**A66 Northern Trans-Pennine Project  
TR010062**

**Development Consent Order Application  
6.1 Errata Report (Rev 2) Tracked**

**24 January 2023**

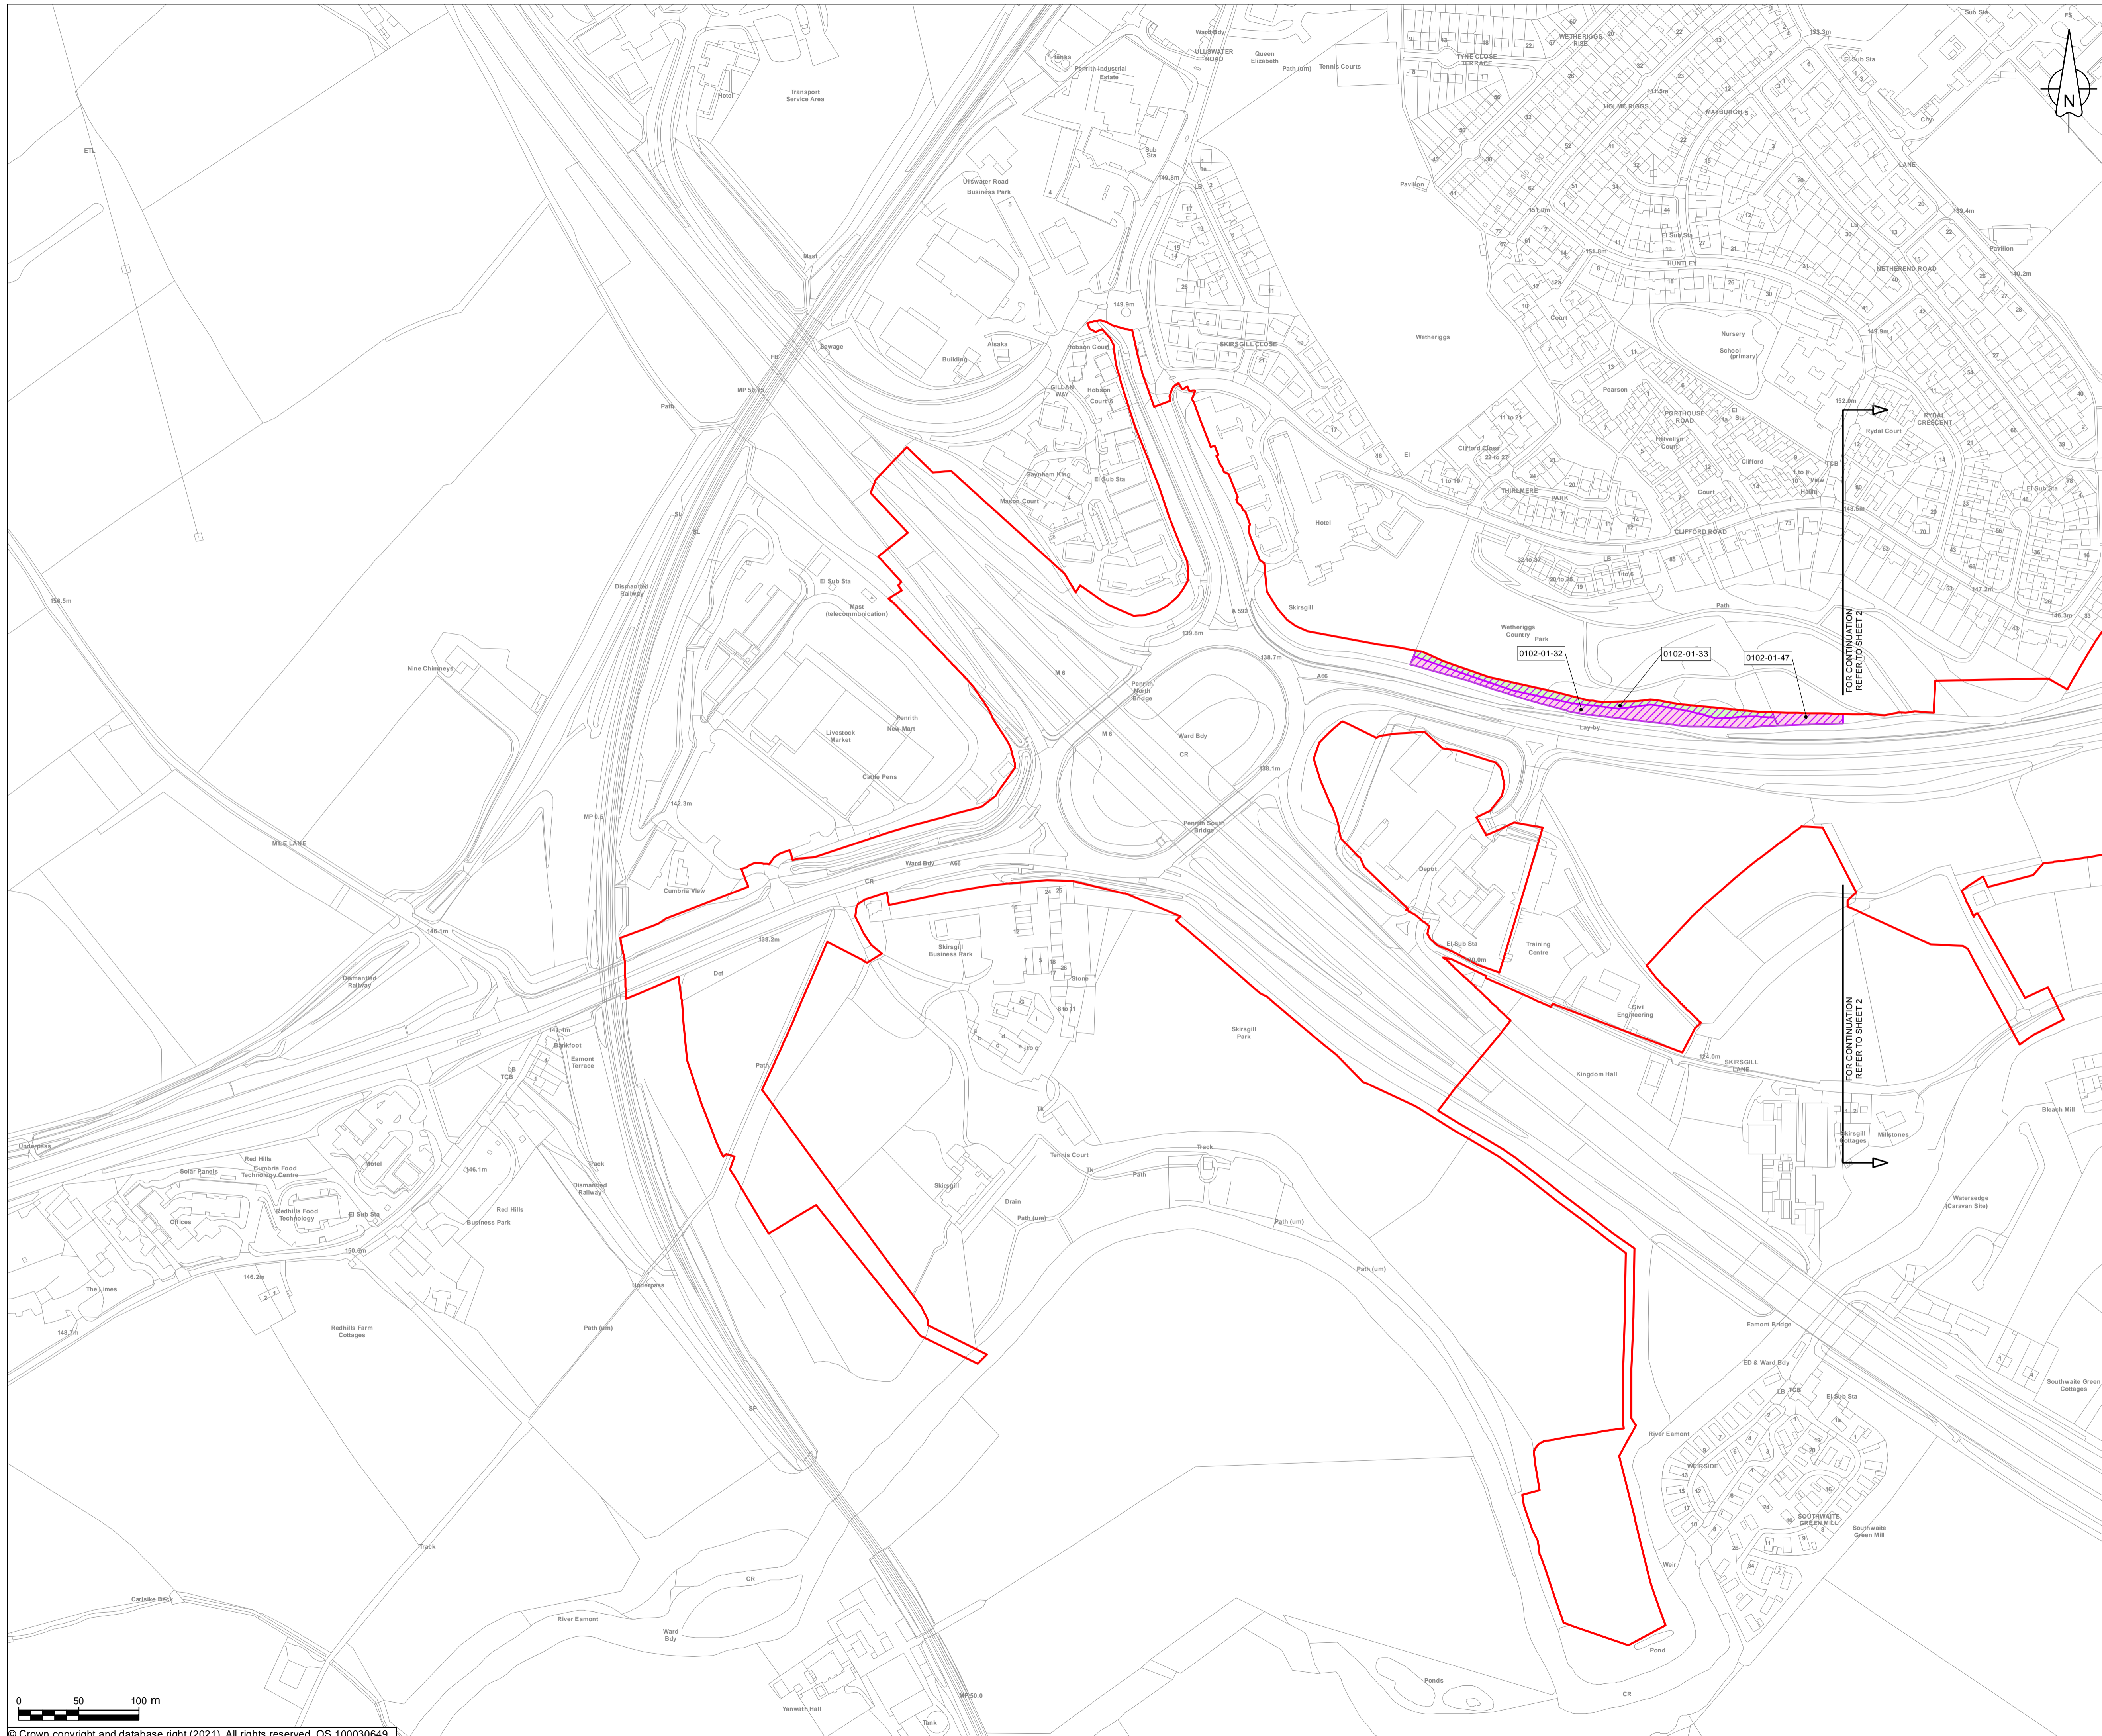
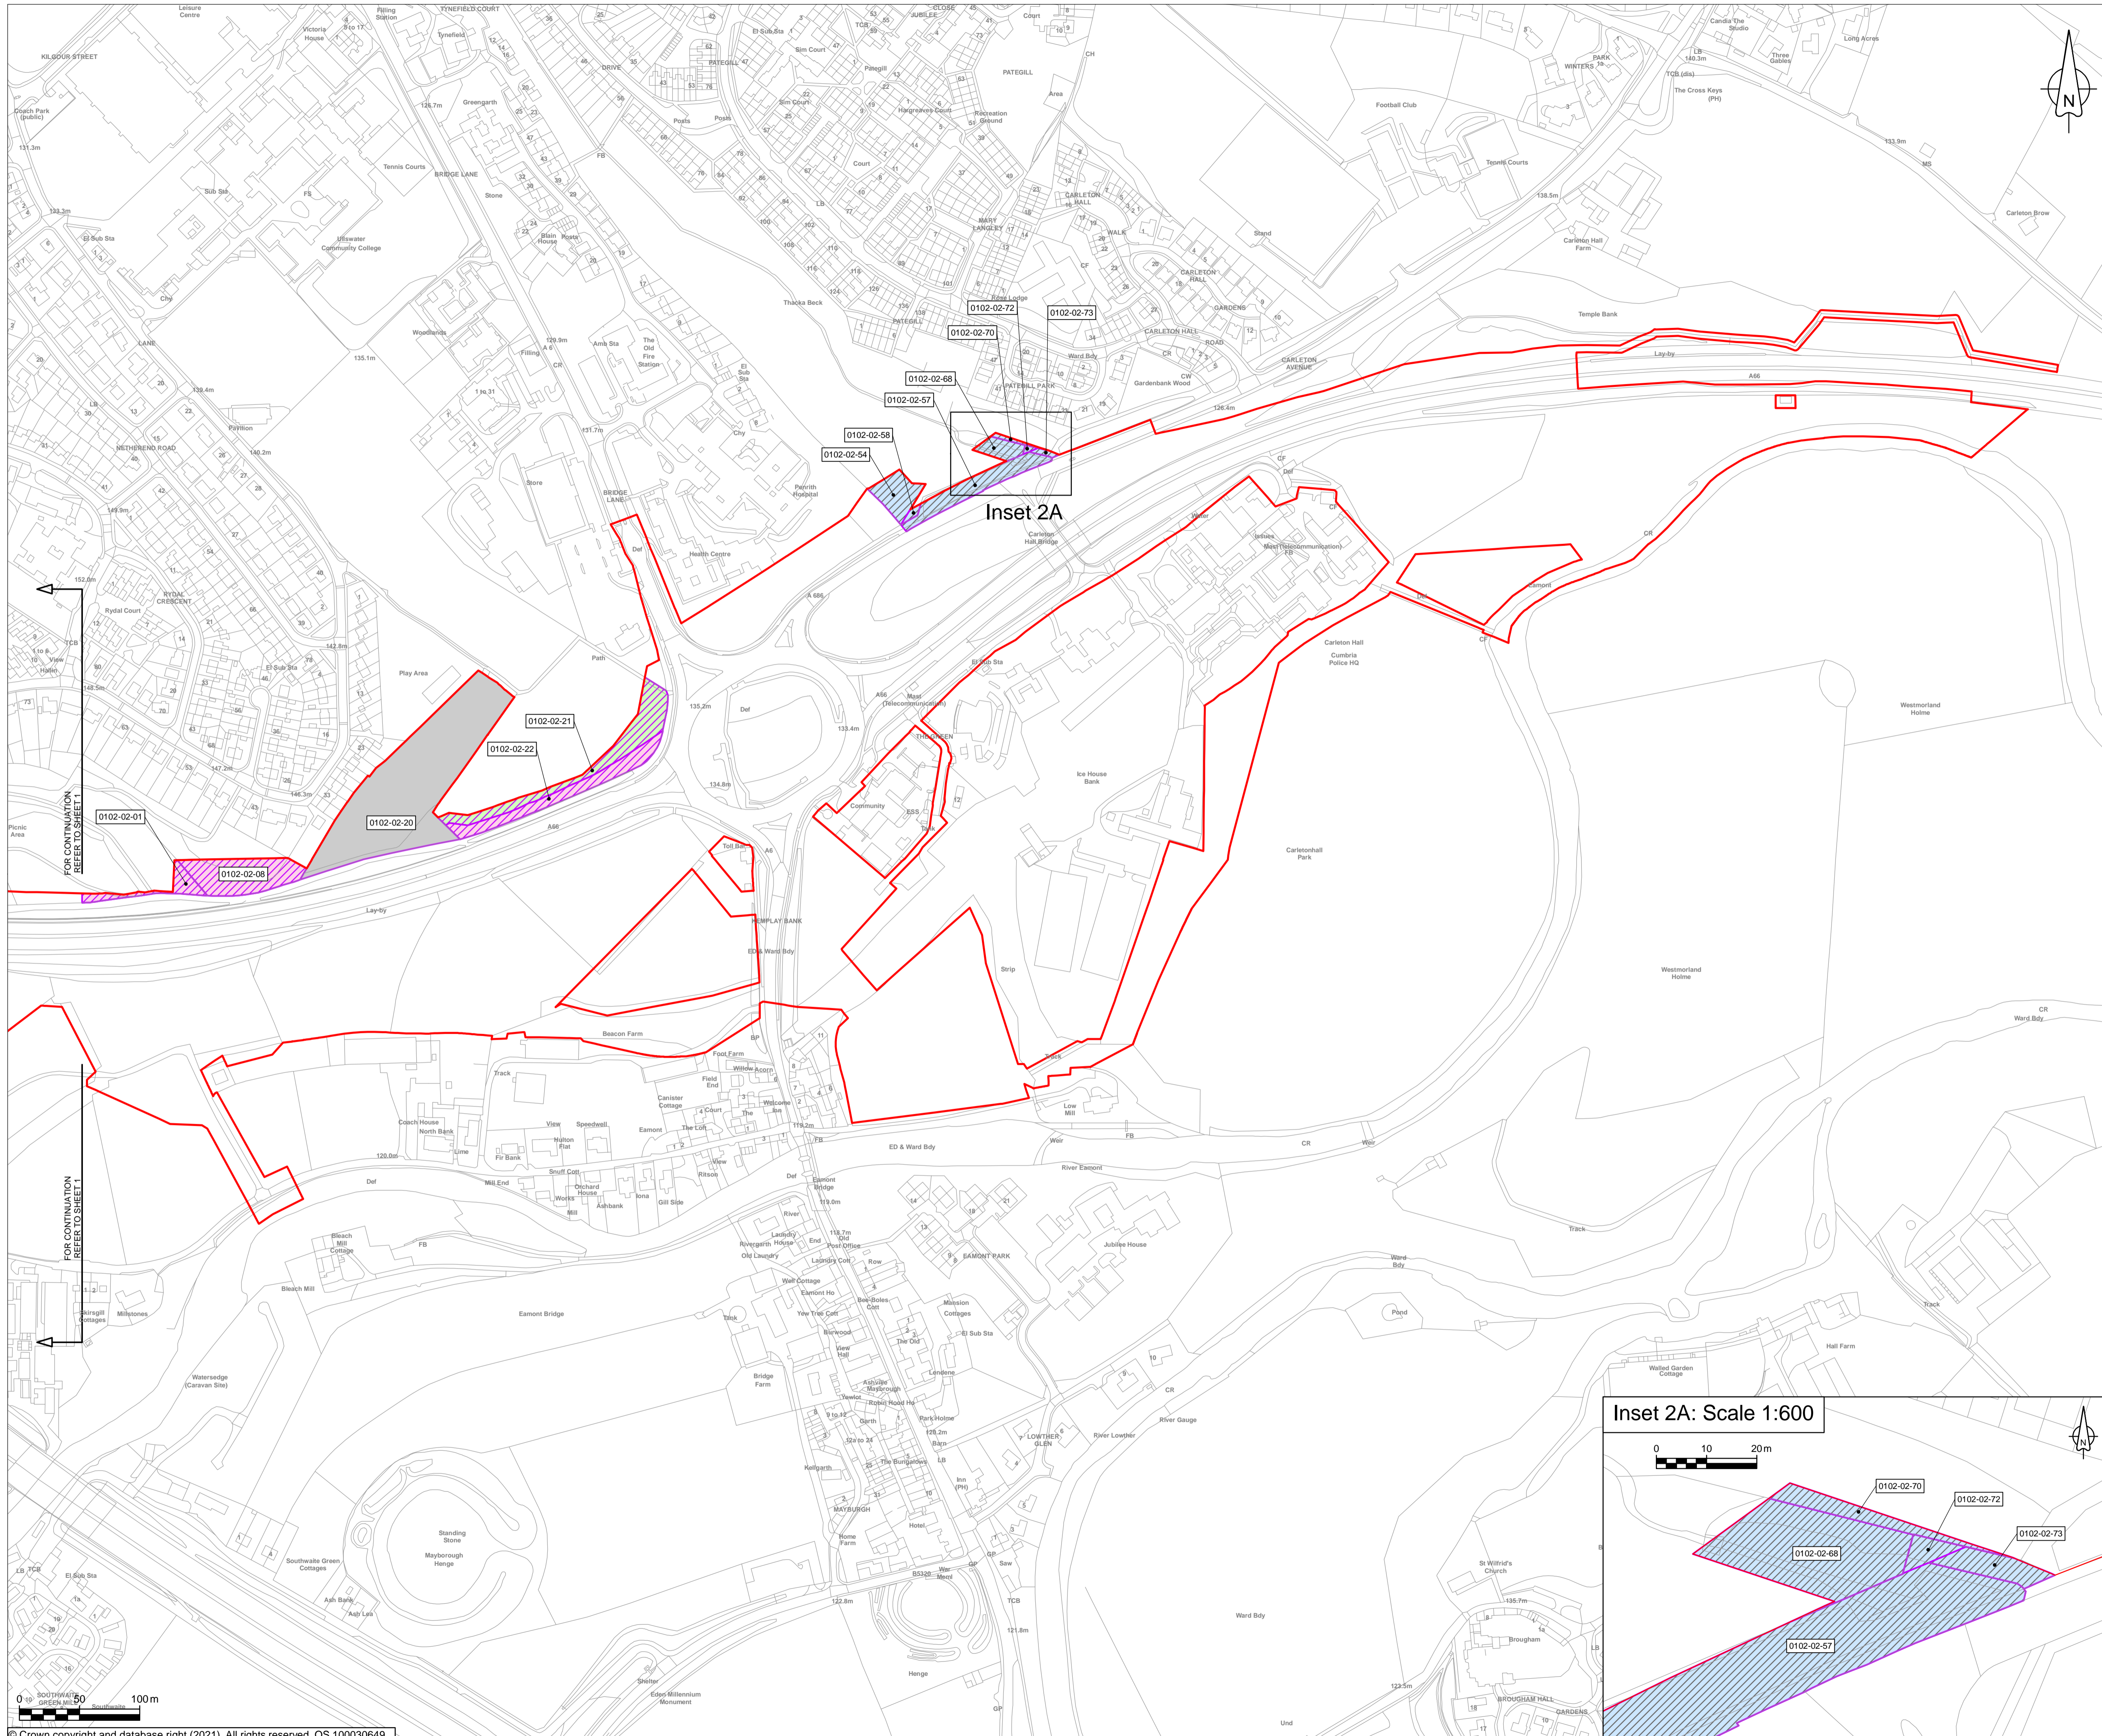
Application Document Reference	Section and Paragraph Reference	Nature of Erratum and Explanation	Amendment / Replacement Text																																									
<b>(This has now been amended in 5.8 Statement of Reasons, Rev 2 (REP2-012) which was submitted at Deadline 2).</b>			provided to the north and to the south of the road to facilitate access to ponds for maintenance purposes and to accommodate landowner movements.																																									
APP-299 5.8 Statement of Reasons <b>(This has now been amended in 5.8 Statement of Reasons, Rev 2 (REP2-012) which was submitted at Deadline 2).</b>	Paragraph 7.2.10 – associated table	Plot 0102-02-54 was not included within the table.

<table><tr> <th data-bbox="1039 491 1223 604">Land use powers sought in the DCO</th> <th data-bbox="1223 491 1373 604">Plots</th> <th data-bbox="1373 491 1473 604">Area (sqm)</th> <th data-bbox="1473 491 1653 604">Replacement land to be provided</th> <th data-bbox="1653 491 1778 604">Plots</th> <th data-bbox="1778 491 1906 604">Area (sqm)</th> </tr><tr> <td data-bbox="1039 799 1223 1054">Land to be subject to the creation and acquisition of new rights (permanent rights for environmental mitigation)</td> <td data-bbox="1223 799 1373 1054">0102-02-54 0102-02-57 0102-02-58 0102-02-68 0102-02-70 0102-02-72 0102-02-73</td> <td data-bbox="1373 799 1473 1054">3,595 4,624</td> <td data-bbox="1473 799 1653 1054">No, because the land, when burdened with the new rights will be no less advantageous than before</td> <td data-bbox="1653 799 1778 1054">N/A</td> <td data-bbox="1778 799 1906 1054">N/A</td> </tr><tr> <td colspan="6" data-bbox="1039 1193 1906 1225"><b>Total area of special category land on S0102: 16,790 16,819 sqm</b></td> </tr></table>
